CITY OF ALBUQUERQUE

December 13, 2022

Re: Pima Medical Institute/ New Classroom Building
4400 Cutler Ave. NE
30-Day Temporary Certificate of Occupancy
Transportation Development Final Inspection
Architect's Stamp dated 04-26-22 (H17-D054B)
Certification dated 10-12-22

SHEET
TCL003

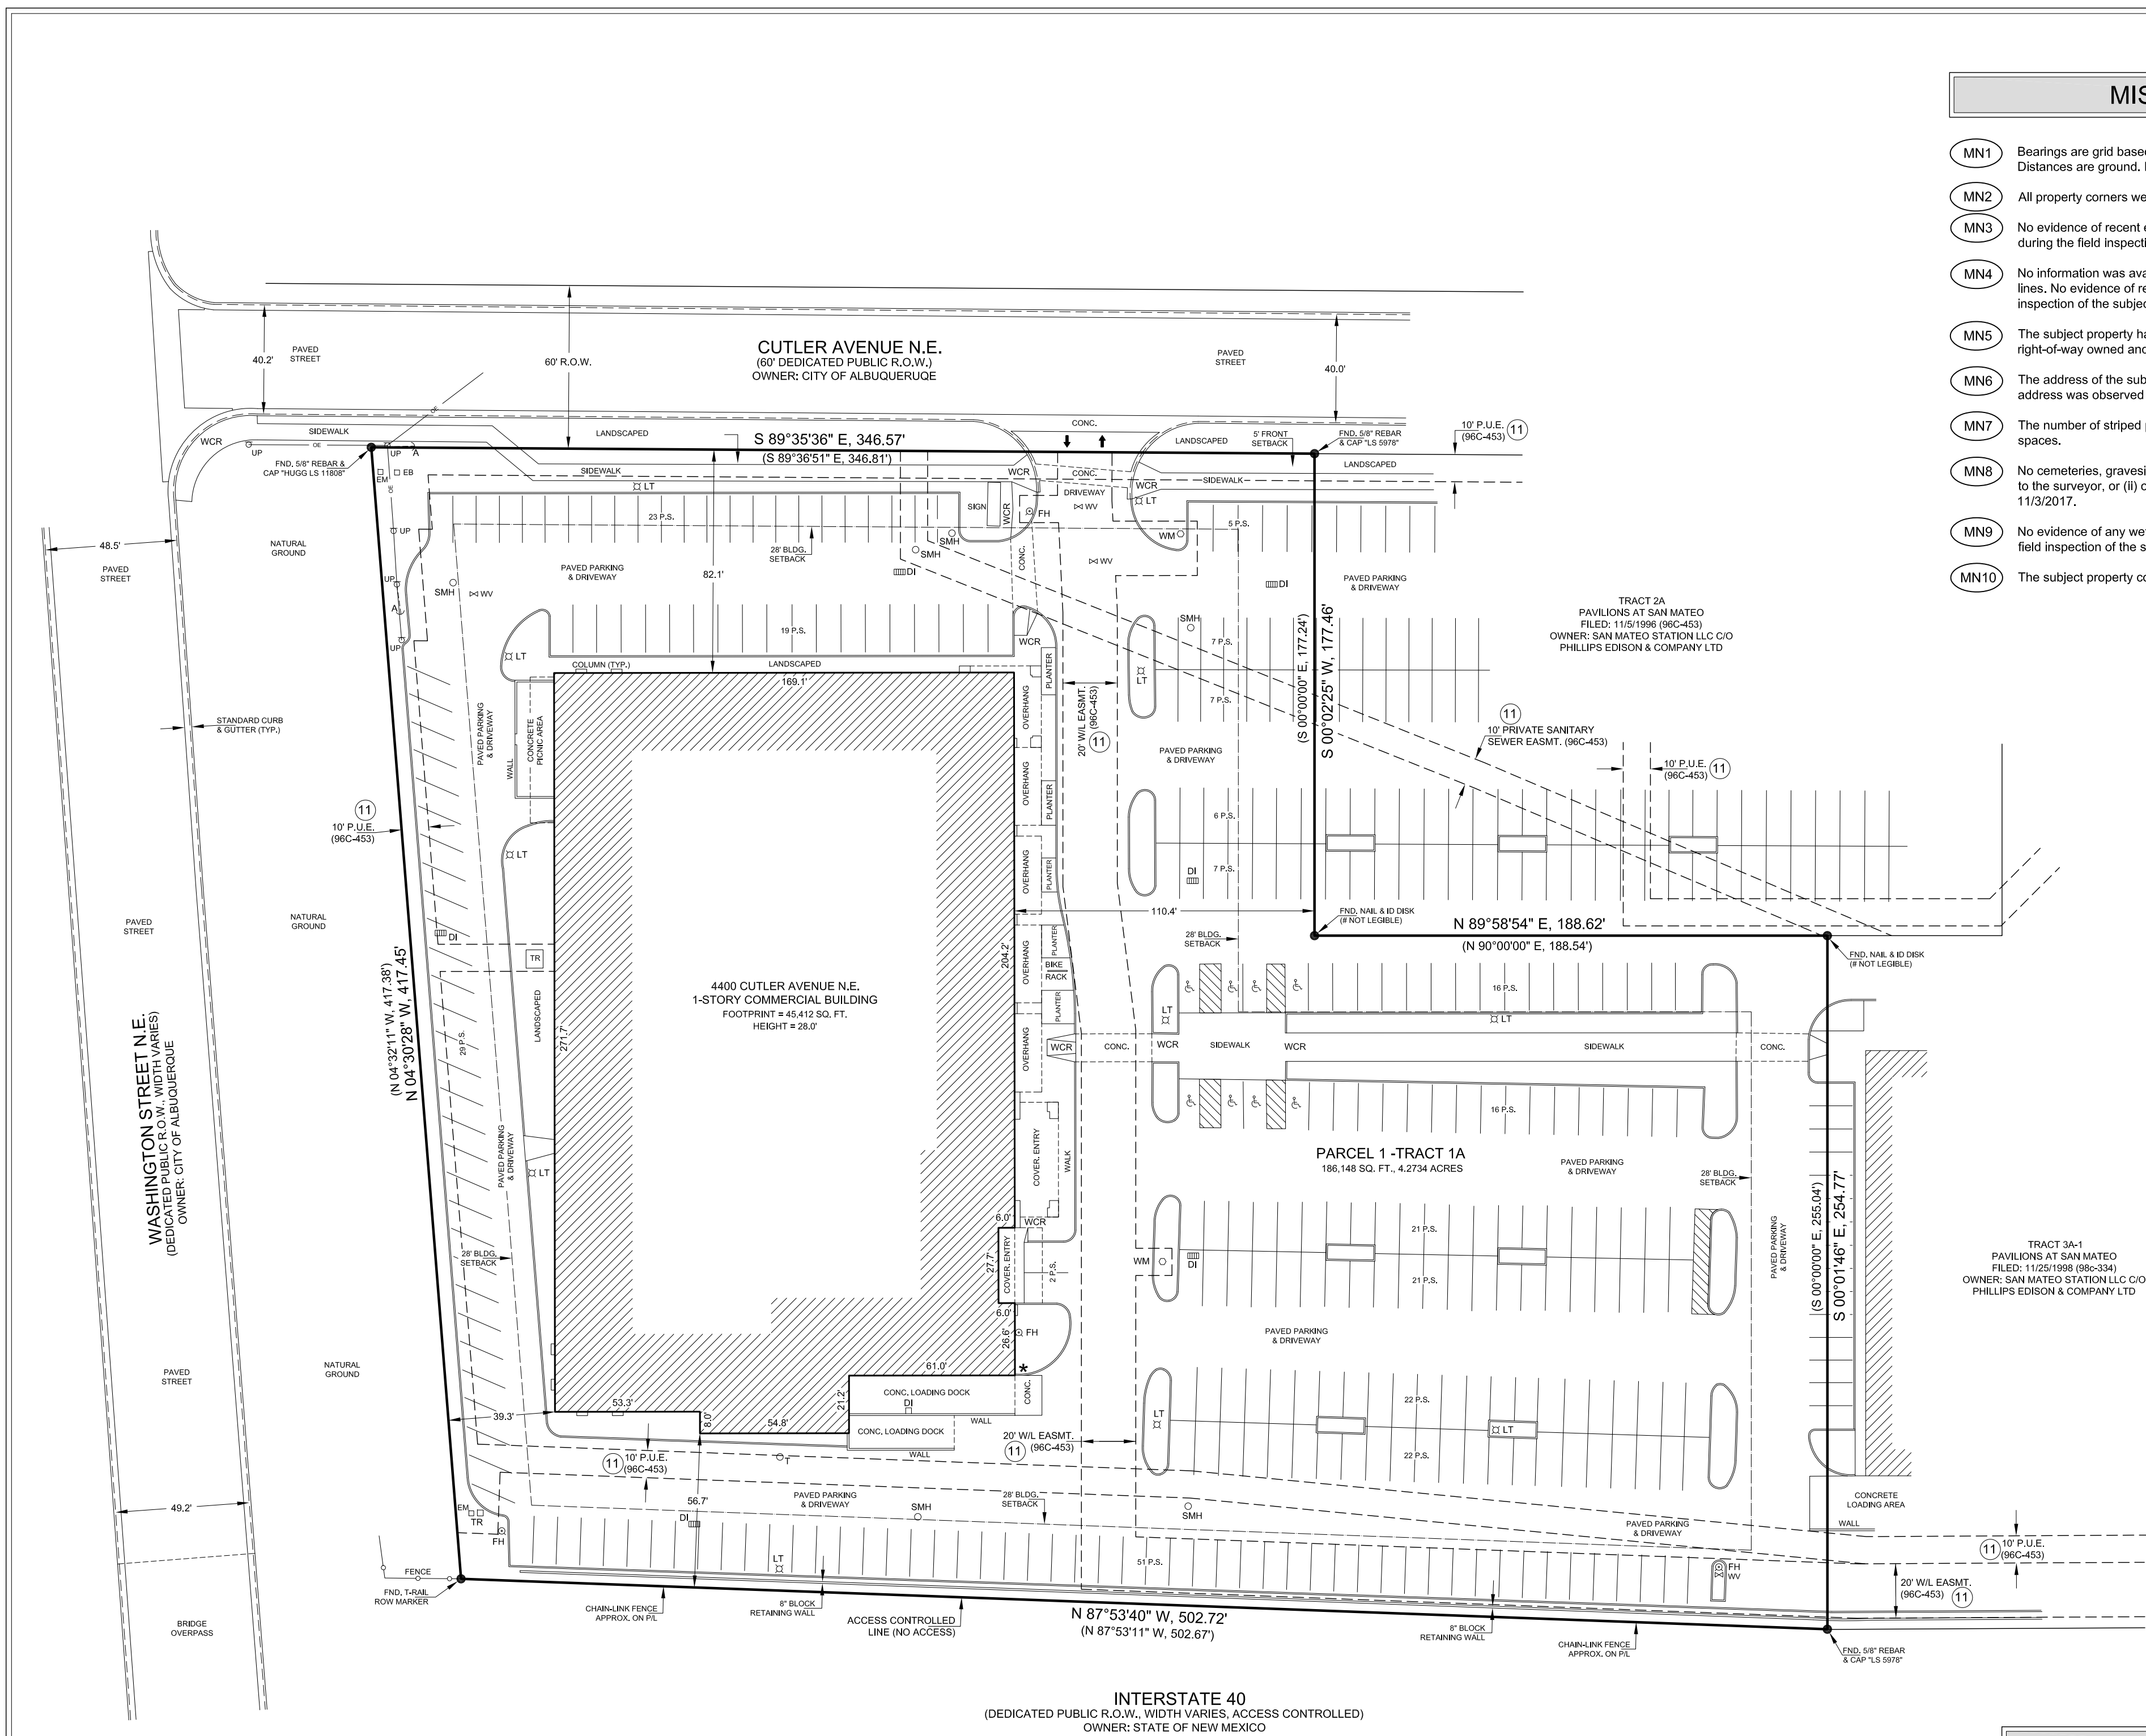
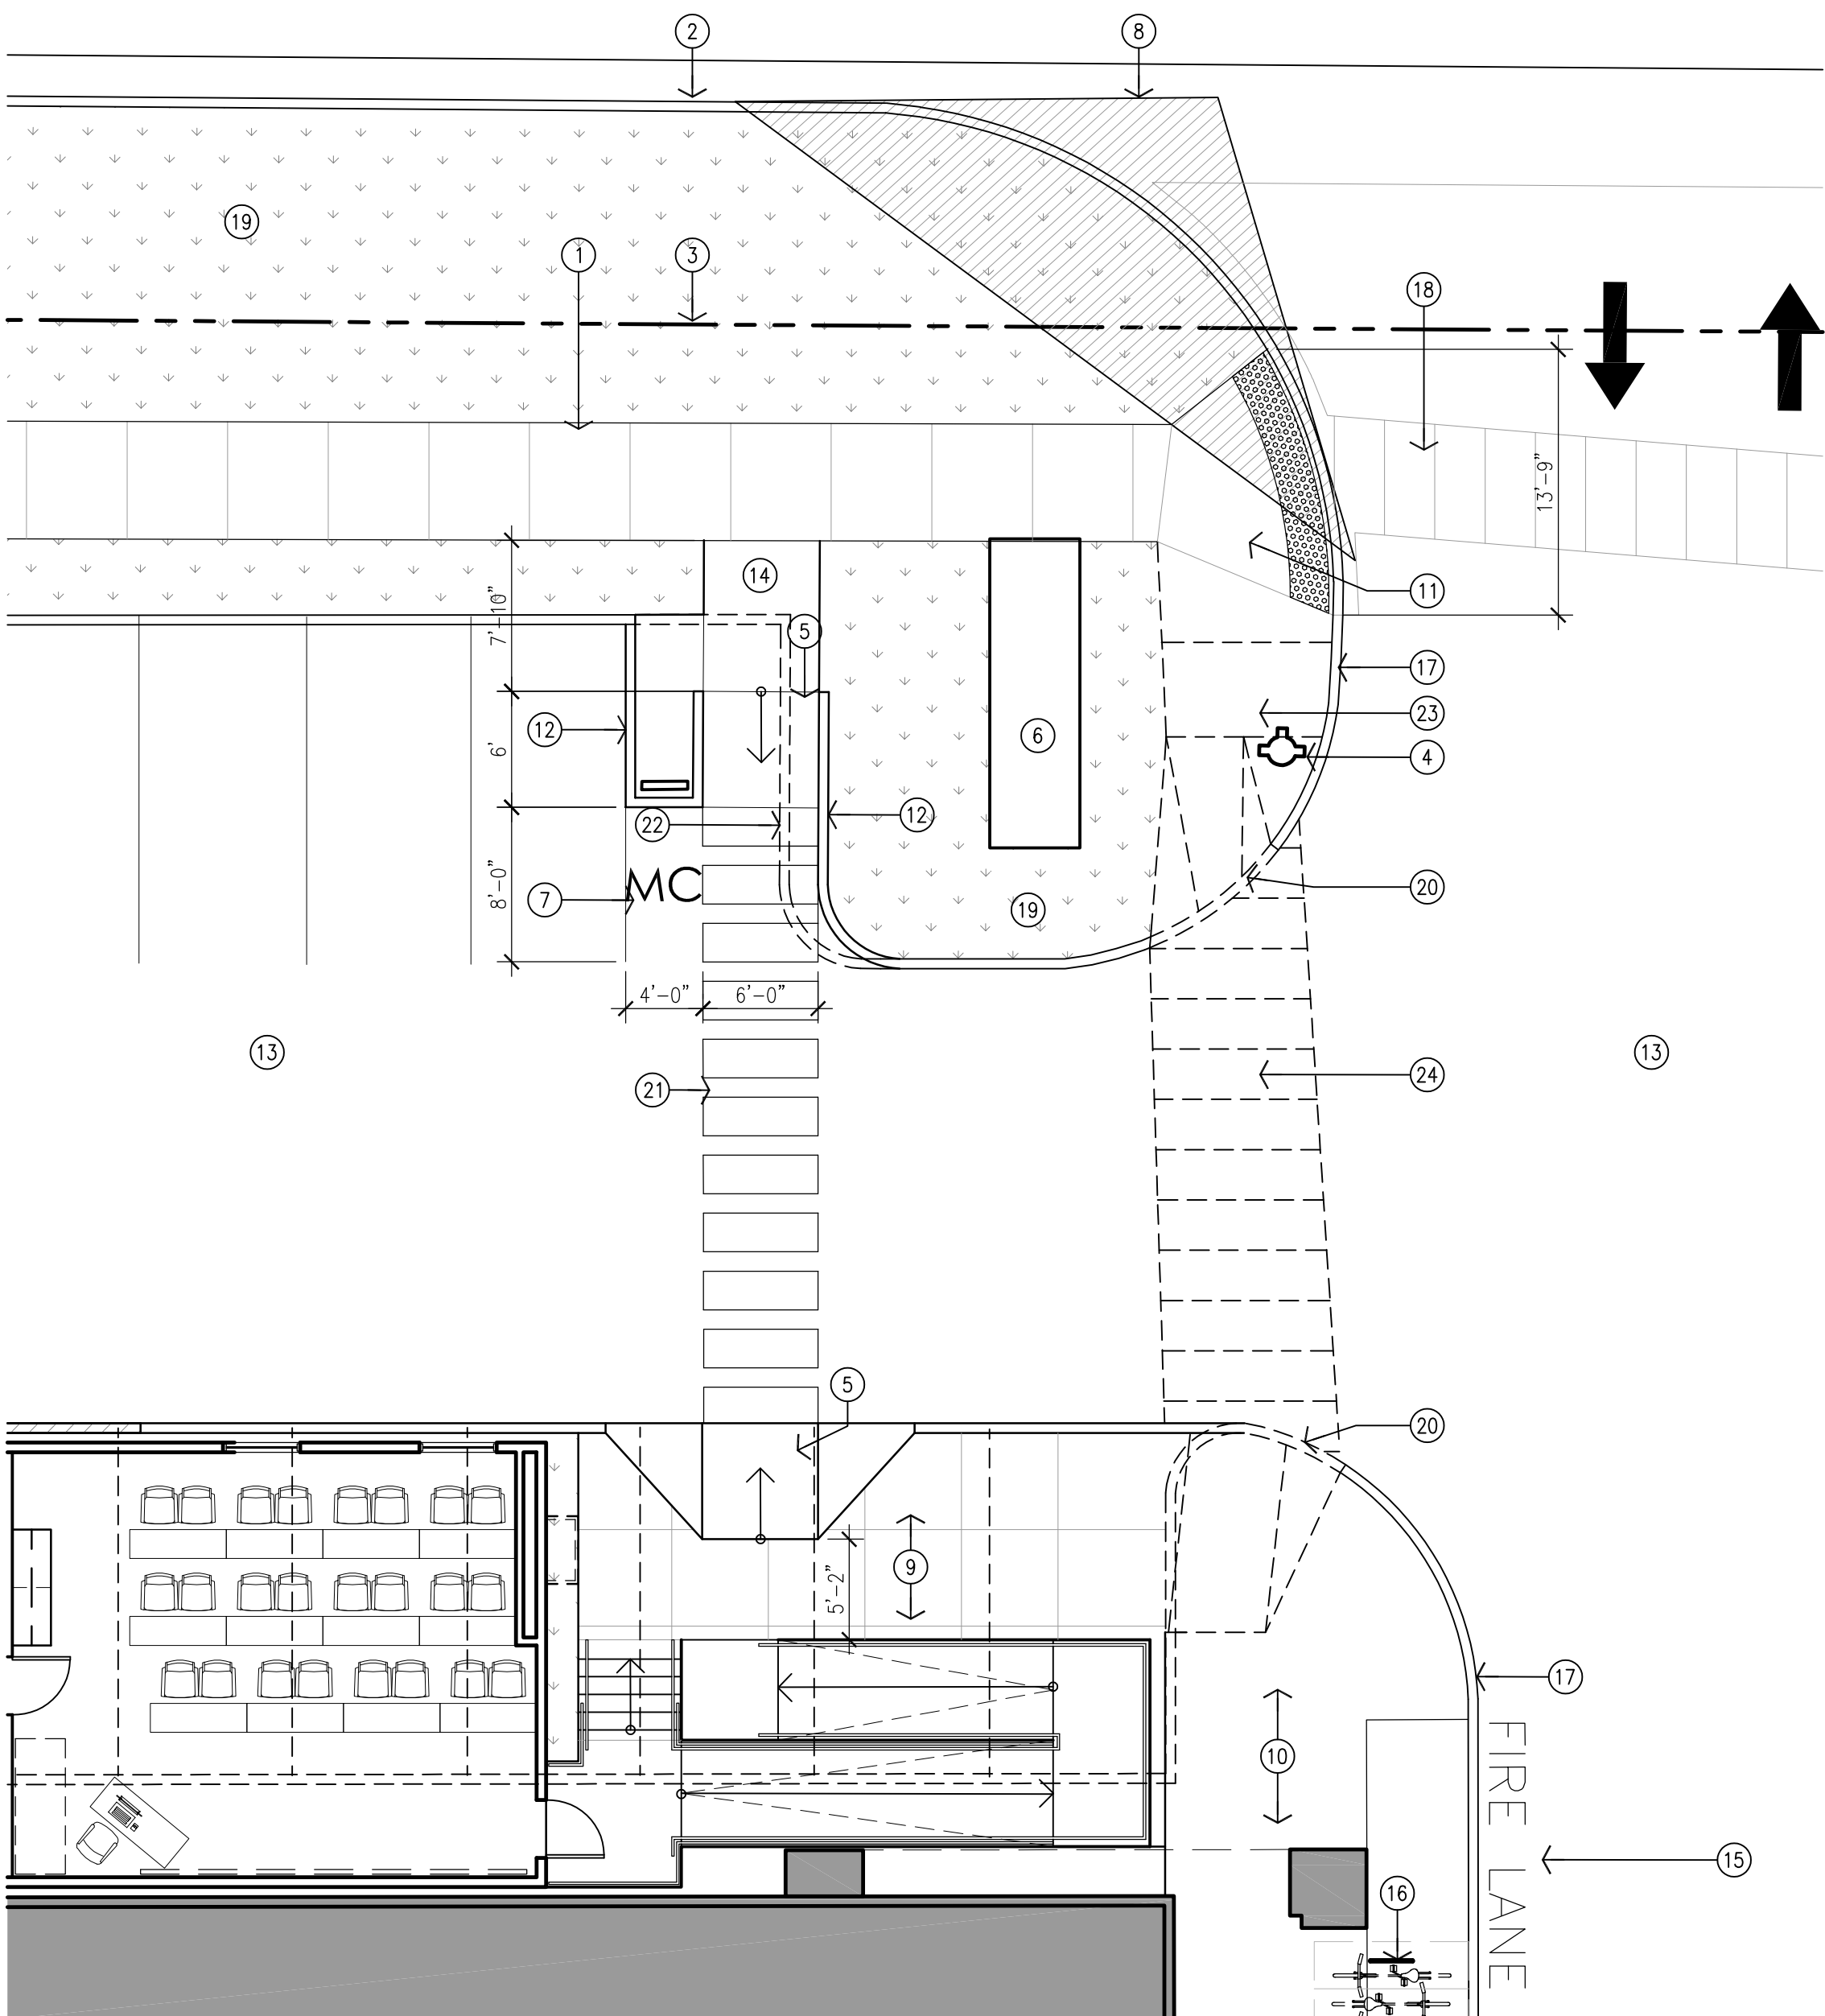
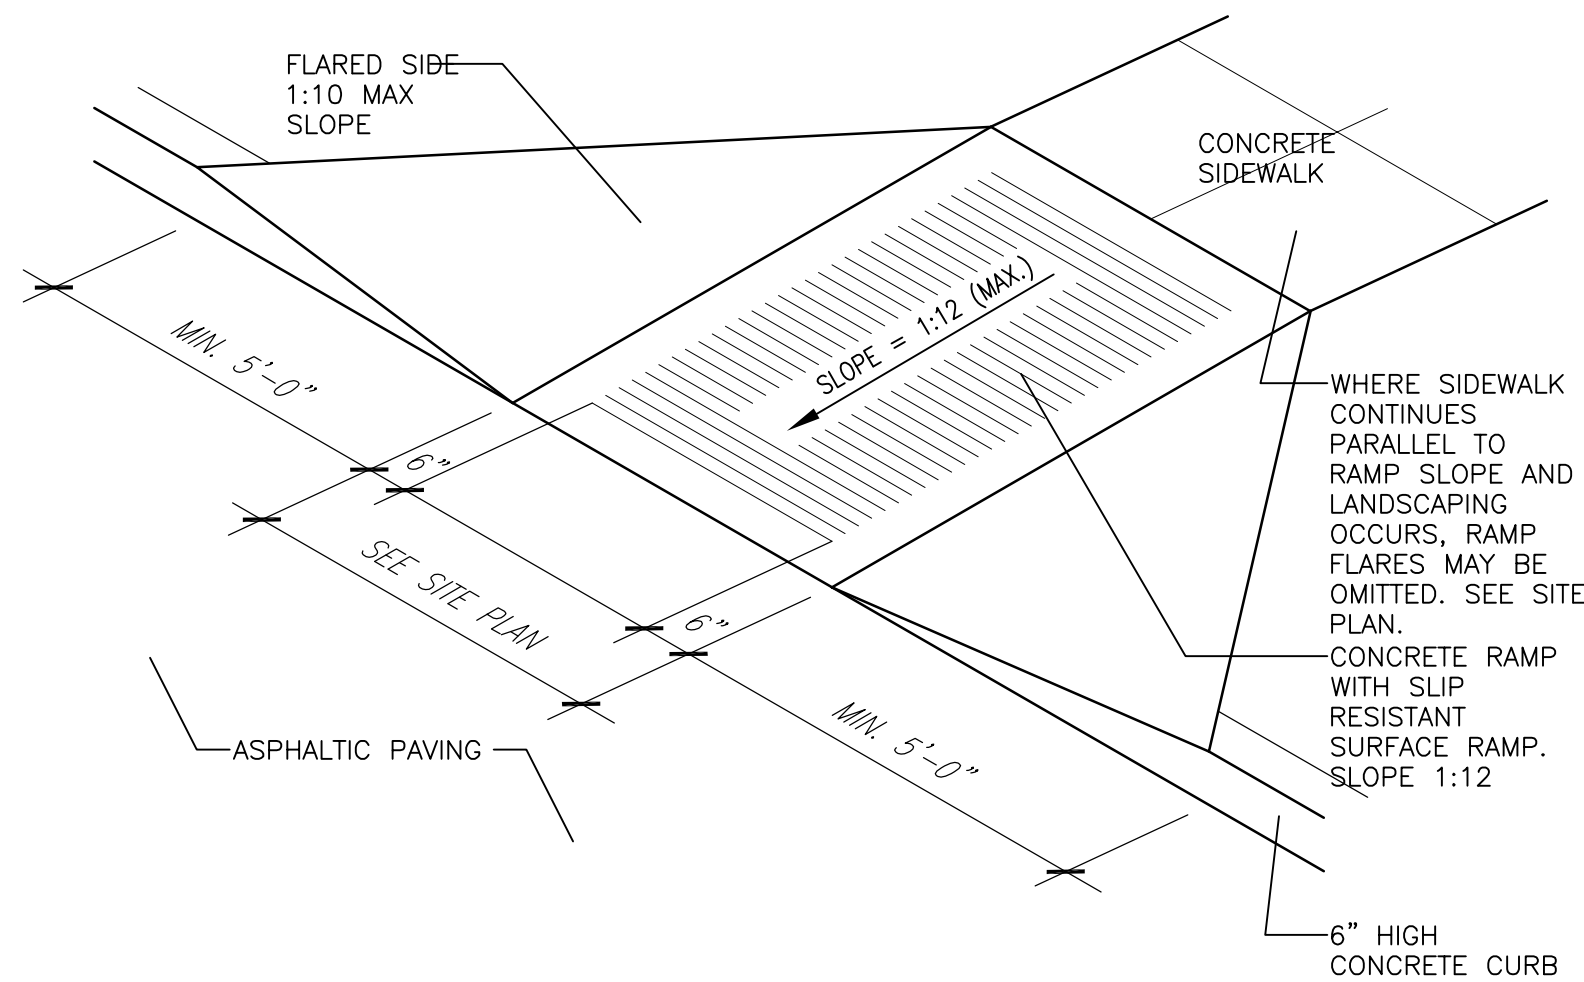
- Keynote 9: per site visit the running slope for the ADA ramp was 9.5%. Per ADA requirements the running slope should not exceed 8.3% (7% preferred slope).
- Keynote 11: Please provide Motorcycle parking spaces per approved plan.
- Keynote 39: Per approved TCL, please provide 6 ft. wide crosswalk.
- Prior to final Certification of Occupancy, please provide City sidewalk easement.
